Ribble Valley Borough Council
Council Offices
Church Walk,
Clitheroe
Lancashire
BB7 2RA

Phone: 0300 123 6780
Email: developeras@lancashire.gov.uk
Your ref: 3/2025/0647
Our ref: 3/2025/0647/HDC/KW
Date: 19 September 2025

Location: Clitheroe Football Club Shawbridge Street Clitheroe BB7 1LZ
Proposal: Proposed demolition of existing clubhouse and construction of new clubhouse and community hub.
Grid Ref: 374720 441735

Client: Clitheroe Football Club Ltd.		
Project: Proposed New Clubhouse & Community Hub Shawbridge Pendle Road Clitheroe		
Dwg title: Proposed Site Plan		
Scale @ A3: 1:500	Date: 04.08.25	Drawn by: PD
Drawing no. 1720 - 102	Rev. -

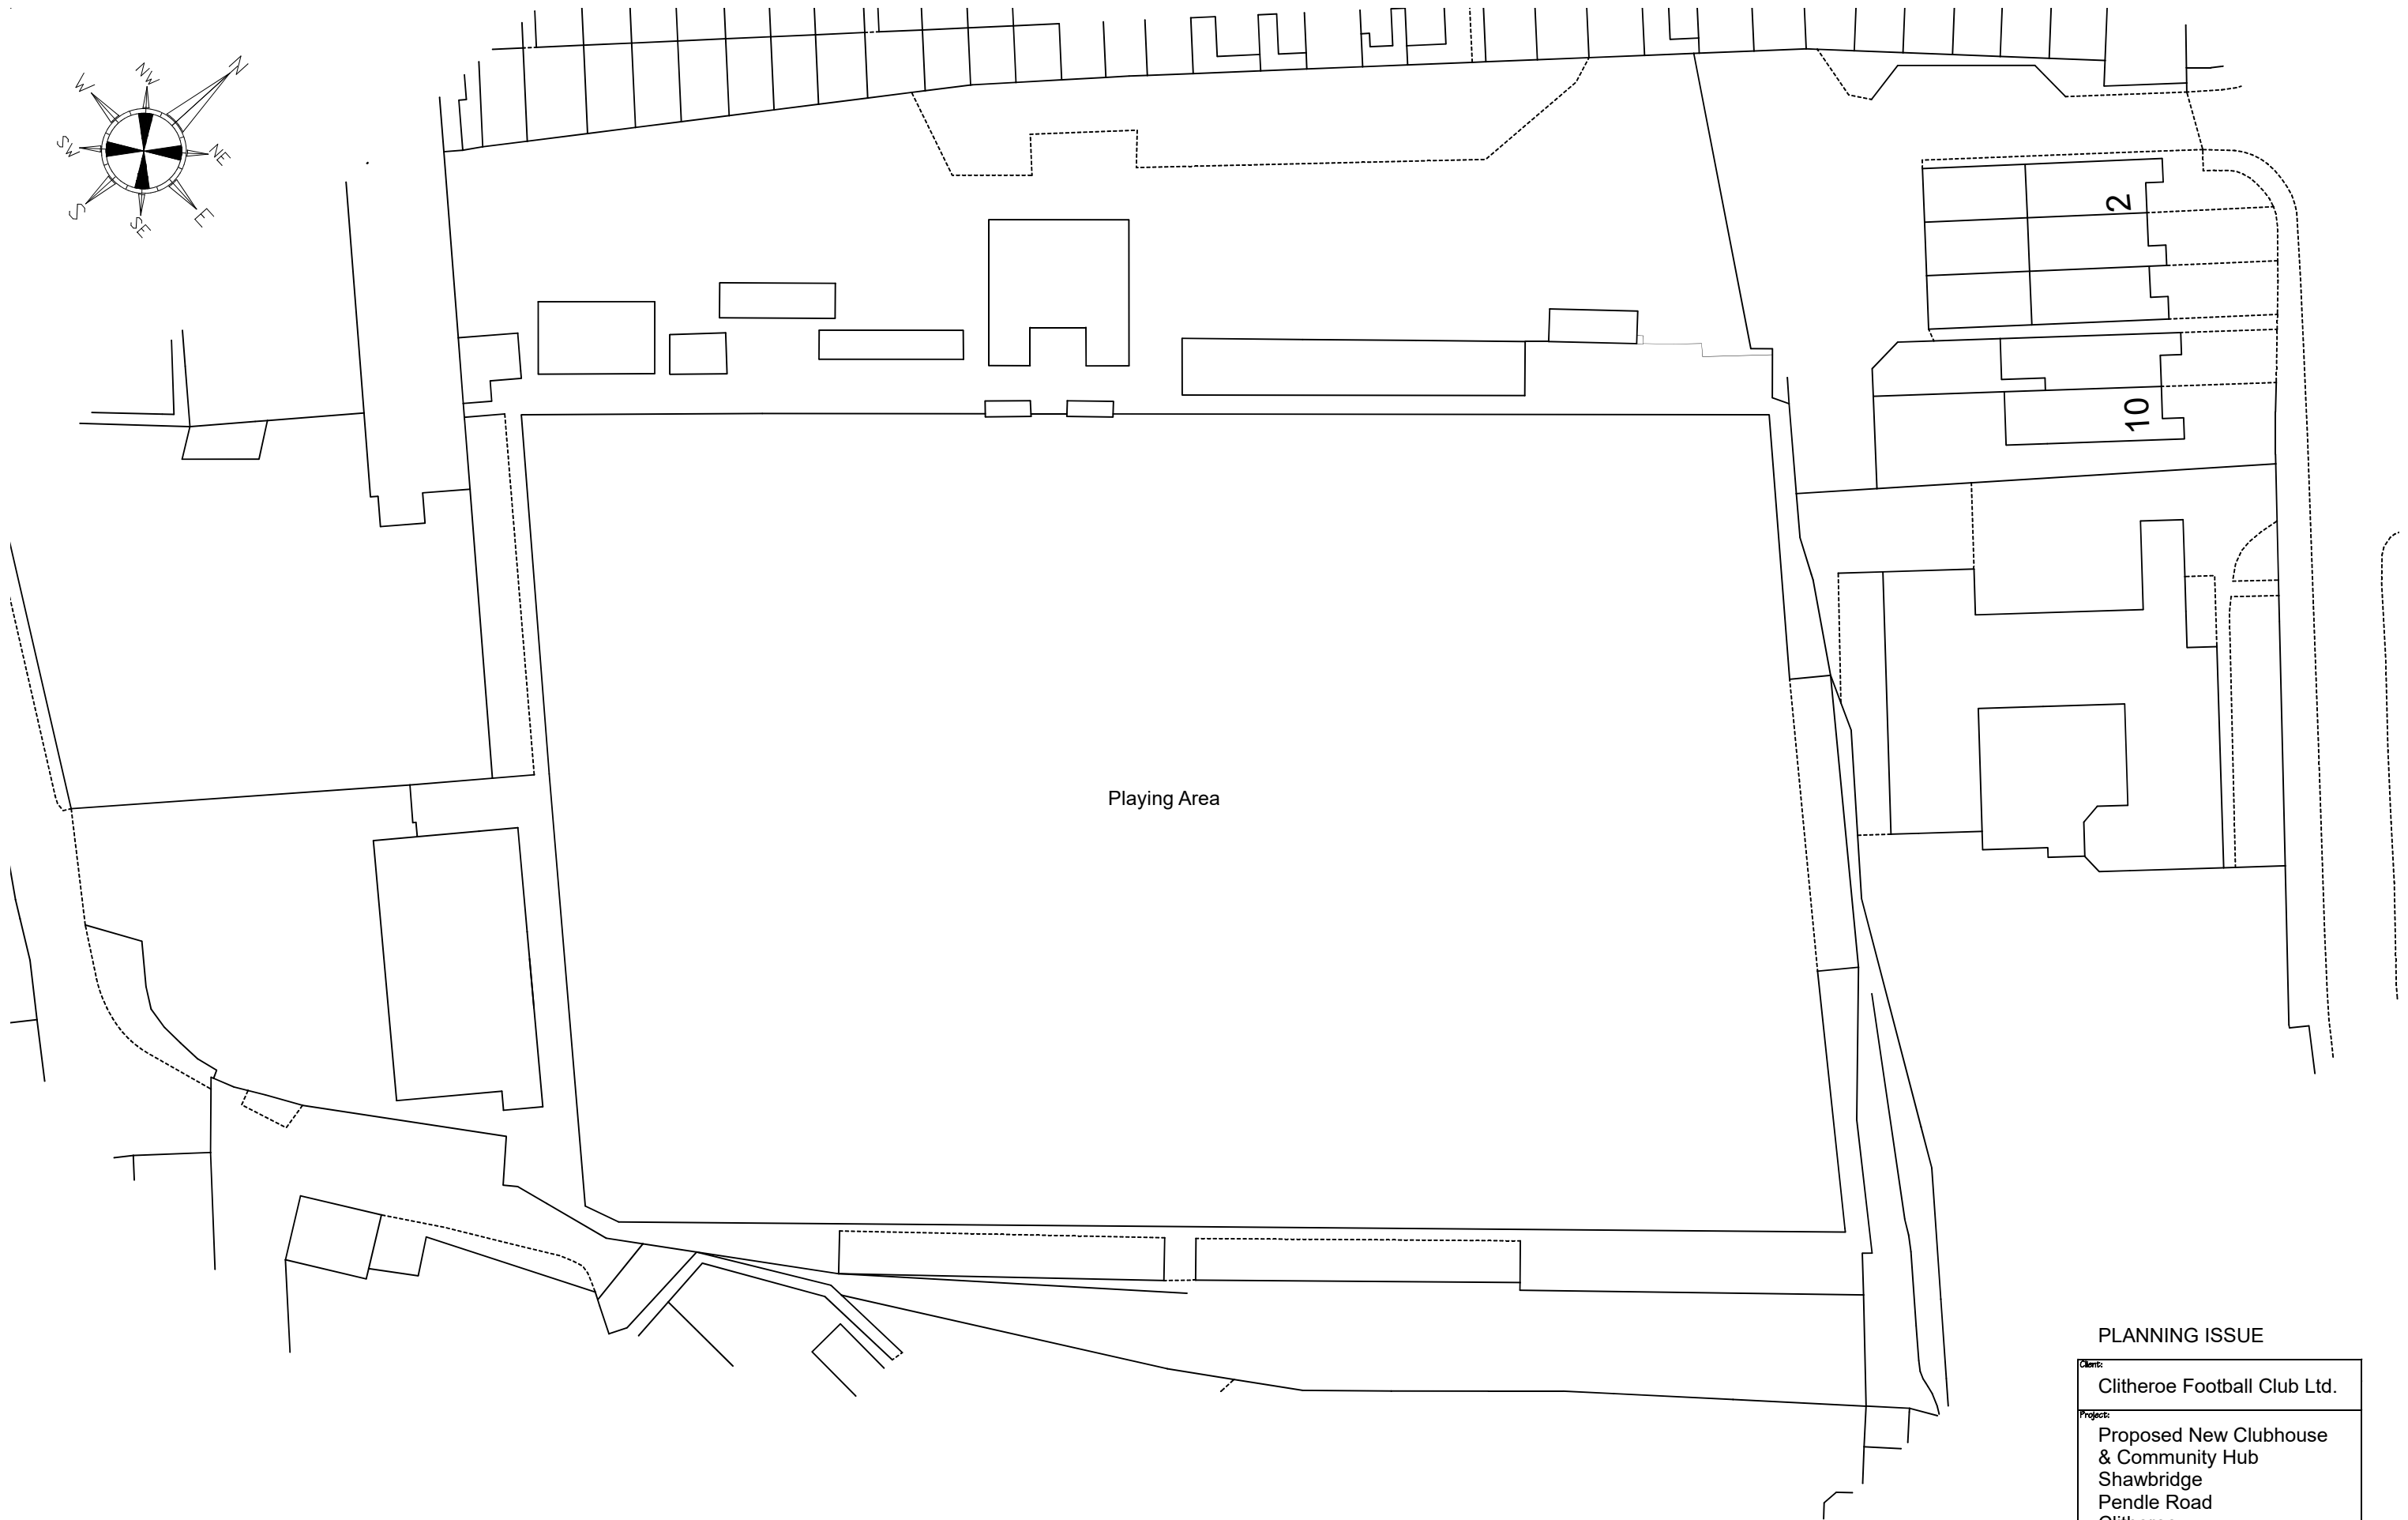
The LHA have reviewed drawing number 1720 - 102 titled "Proposed Site Plan" and are aware that the site accesses, on Bright Street and Shawbridge Street, will remain unaltered following the proposal. Therefore, the LHA have no further comments to make regarding the access.

Whilst the LHA acknowledge that the parking provisions, previously agreed under application 3/2021/0690, would only serve players, management, match officials and club media. These provisions could be offered during daytime events held within the community hub as such, they should be included within this proposal and the LHA would look for a parking plan to be included as part of this proposal.

The access road between Bright Street and the car park is privately maintained and without a separate footway, due to the sub-standard layout and lack of separate footways and street lighting, the LHA would only look for this access to be used only during the daytime and as such would not support the use during private events held on Saturdays evenings for example.

The applicant should provide a revised parking plan, a comprehensive operating statement with clearer event logistics, and assurances regarding parking and access restrictions.
